KIRKLEES METROPOLITAN COUNCIL INVESTMENT & REGENERATION SERVICE

DELEGATED DECISION TO DETERMINE PLANNING APPLICATIONS

Reference No:	2026/62/90035/W
Site Address:	4, Rushfield Vale, Fenay Bridge, Huddersfield, HD8 0BX
Description:	Erection of single storey rear extension and raised decking area
Recommending Officer:	Joanna Rednall

DECISION – CONDITIONAL FULL PERMISSION

PROPOSED REAR ELEVATION

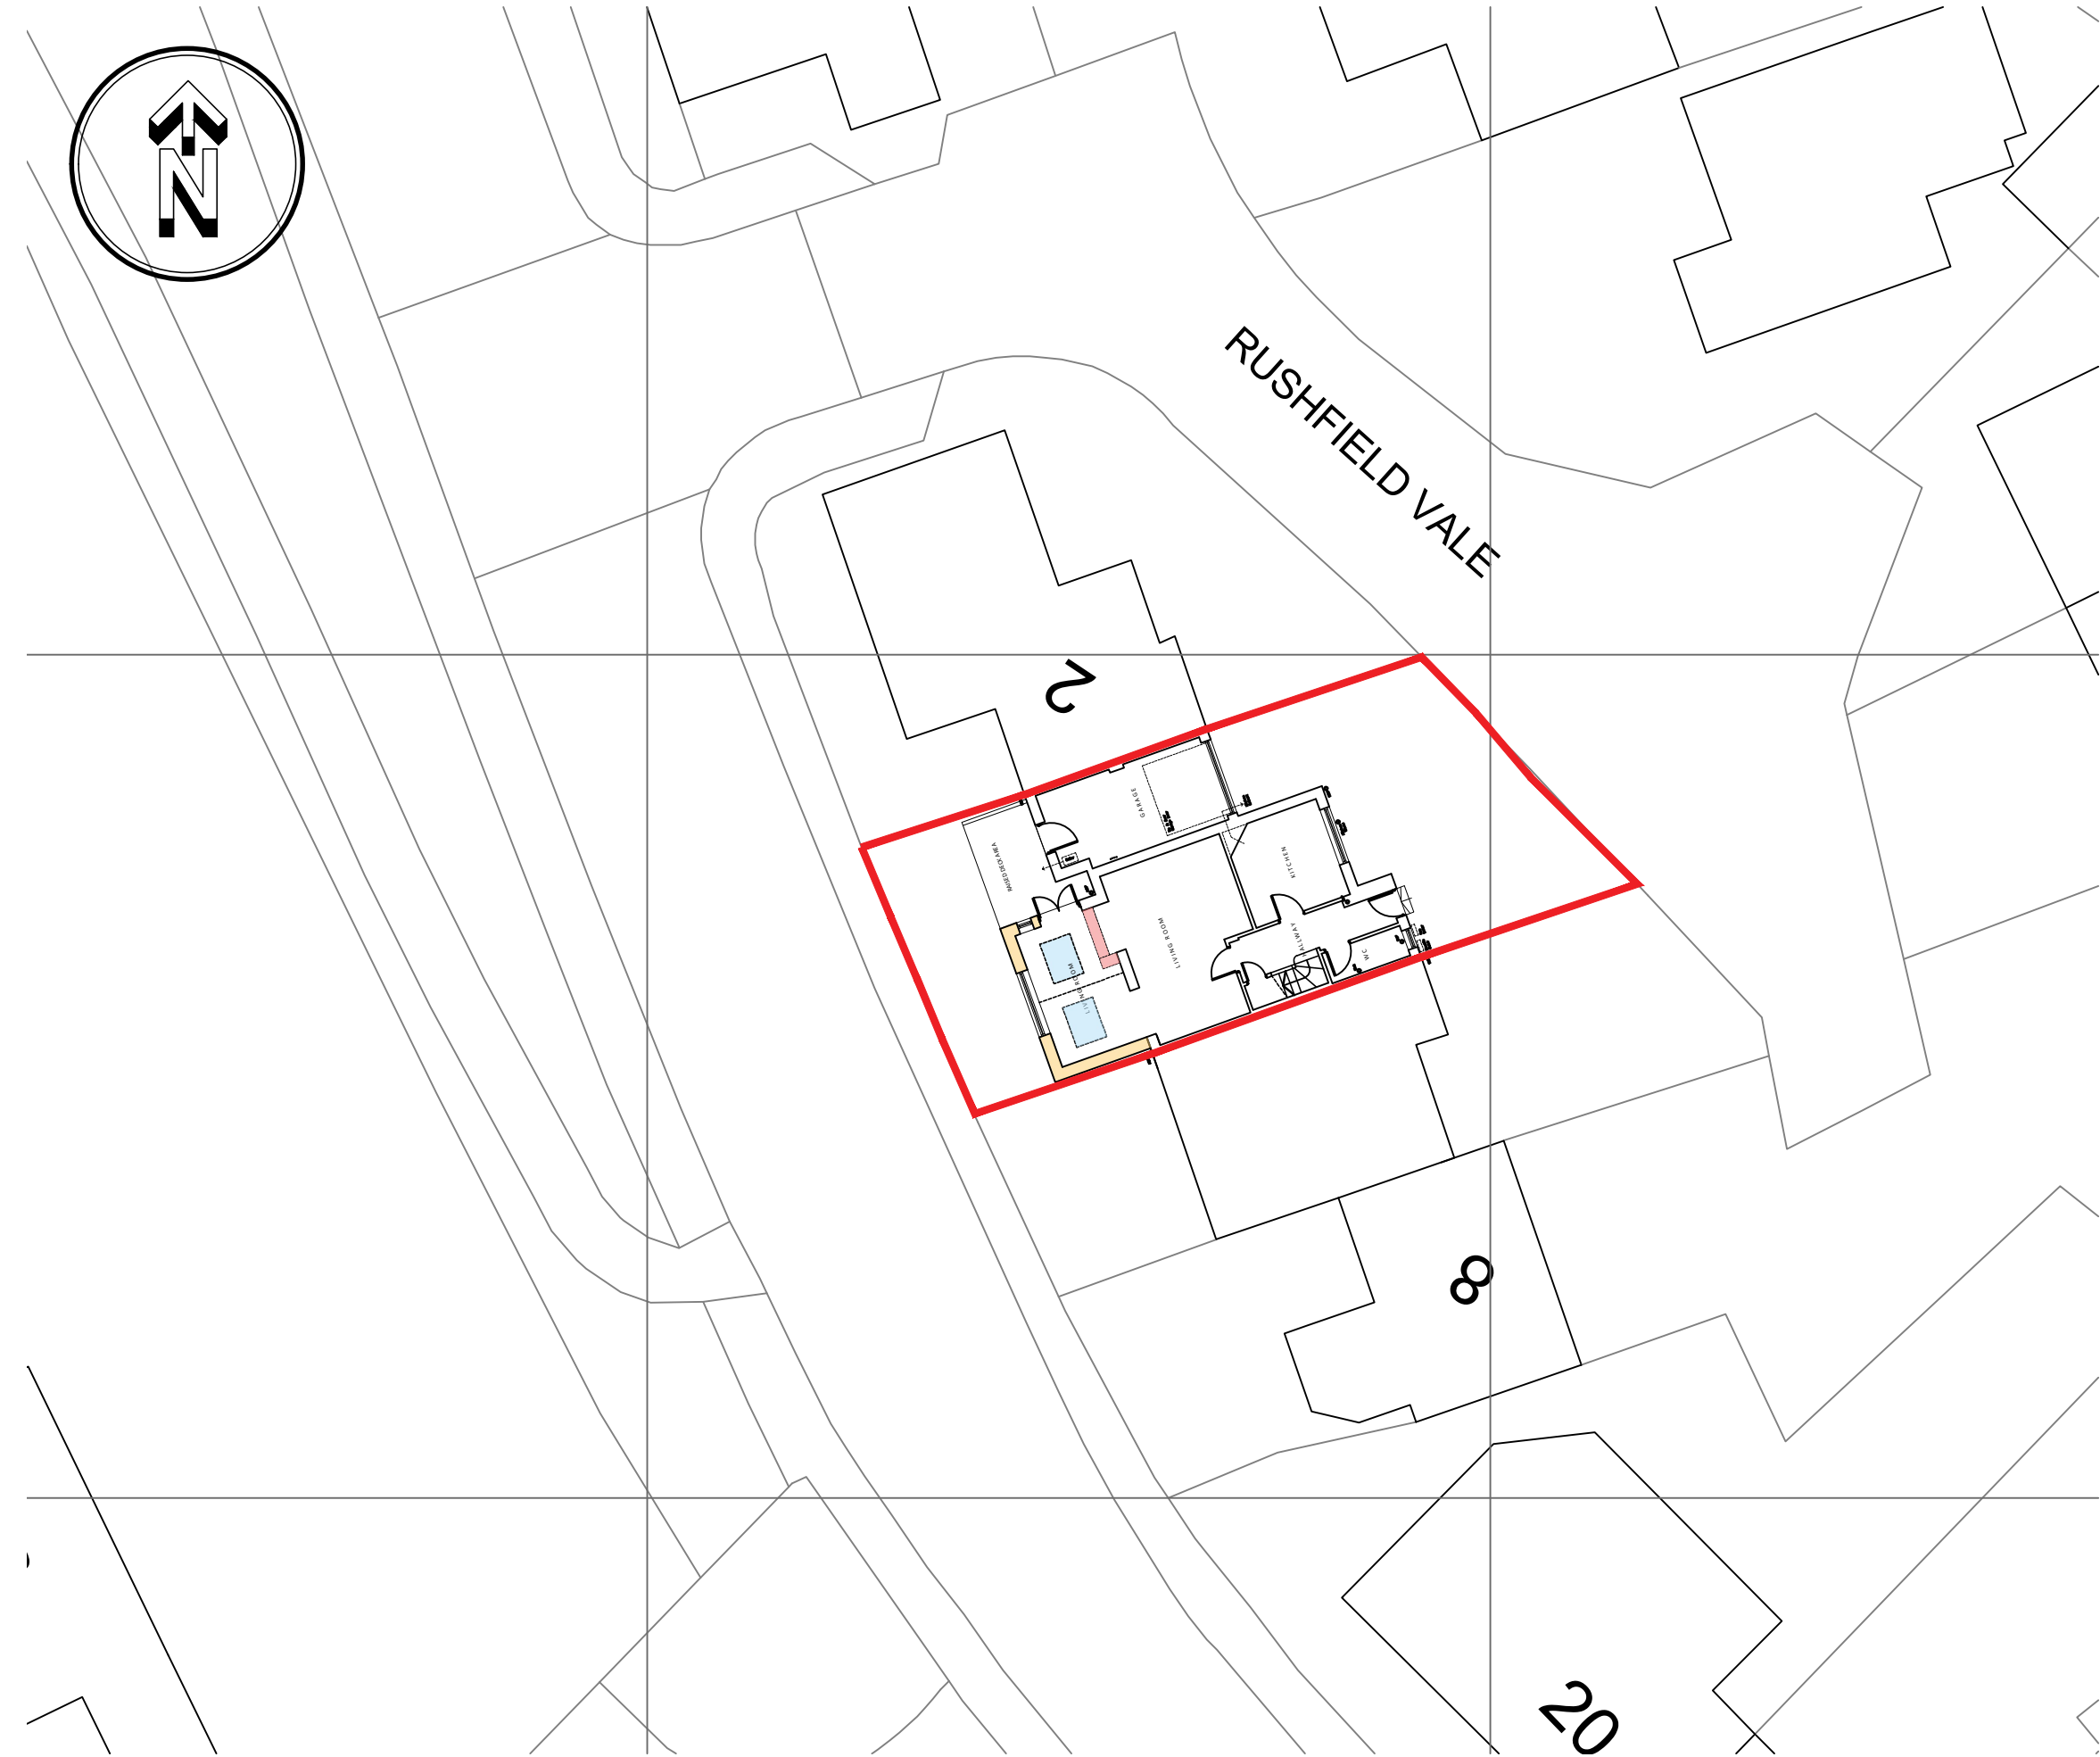
The proposed rear extension is considered to appropriately conform to the recommendations / principles as set out in the SPD. Although it has been acknowledged that the rear extension is not set 1 metre away from the neighbouring boundary to the south, with only a gap of 0.2 metres to be retained, as the side elevation of the building to be extended is sited along the shared boundary, it is considered there would be no design benefit in setting the extension in by a whole metre and it would be unreasonable of the LPA to request such an amendment in this case.

From a visual amenity perspective, the proposed single-storey rear extension at 4 Rushfield Vale is considered to read as a subservient addition that accords with the size and scale guidance set out in the SPD. Although positioned to the rear, this elevation is visually prominent due to its elevated setting and its relationship with Fenay Bridge Road. Even so, officers consider that the proposal's sympathetic design, including the use of materials that match the host dwelling and fenestration that reflects the original architectural style on both the rear and side elevations, ensures the character of the dwelling is preserved and the extension would not result in an obtrusive addition that harms the character of the area. The projection would lie flush with the rear elevation of the adjoining neighbour No.2, therefore it would not encroach beyond the existing building line fronting Fenay Bridge Road. The pitched roof form further reinforces consistency with the design of the existing house.

The raised decking forms a modest and subordinate addition to the rear of the property. It sits between the proposed rear extension and the neighbouring porch to the north, being 0.6 m above ground level and enclosed on its northern edge by a 1.8 m boundary fence. The decking does not extend beyond the rear elevation of the extension, ensuring it remains contained within the established rear building line fronting Fenay Bridge Road. Taken together, these factors mean the structure reads as a modest, domestic feature rather than a visually prominent or intrusive element. Its limited height and restricted footprint in relation to the host dwelling ensure that it does not compete with or overwhelm the original building. Because it is set well back from the public realm and screened from the highway, it avoids any material impact on the street scene or the wider character of the area.

The decking would sit directly alongside the neighbours boundary, with the rear extension itself positioned a further 3.2 m away. A 1.8 m boundary fence is proposed along the northern edge of the decking to provide effective screening. Although an existing hedge currently separates the porch from the application site, the plans indicate this would be removed to facilitate the development. Its removal does not significantly alter the relationship between the two properties, as the replacement boundary treatment would provide a comparable level of screening. The introduction of a solid 1.8 m screen fence in this location is not considered to harm the living conditions of the occupants of No. 2 given the main outlook is to the west and the screen fence does not protrude beyond the western elevation of no.2. The decking itself is modest in scale, being 0.6 m above ground level, and the extension is set back sufficiently to avoid creating any sense of enclosure.

The extension projects 3m along the shared boundary. The siting of this is adjacent to adjoining neighbour, and would be adjacent to patio doors which form a main habitable opening. The proposal would lead to a level of impact to this ground floor opening.

The orientation of the site is such that the overshadowing impact is lessened with the proposal being sited north of the patio door, furthermore the level of projection and size of the opening it is adjacent to within no.6 is such that it is concluded that whilst a 45 degree line would be cut by the proposal (with approx. 1.4m of the side elevation in place beyond the point it is cut) it is considered this would not be of such a significant extent that refusal on the basis of overshadowing could be substantiated in this case when considering the orientation of the site and scale and design of the proposal. The eaves level of the proposal would be at a height whereby they are at the same level as the top of the patio door, and the roof slope moving away from the shared boundary. In this context the extent of built form is not considered to unacceptably overshadow the neighbouring occupier and would not be unduly oppressive / overbearing.
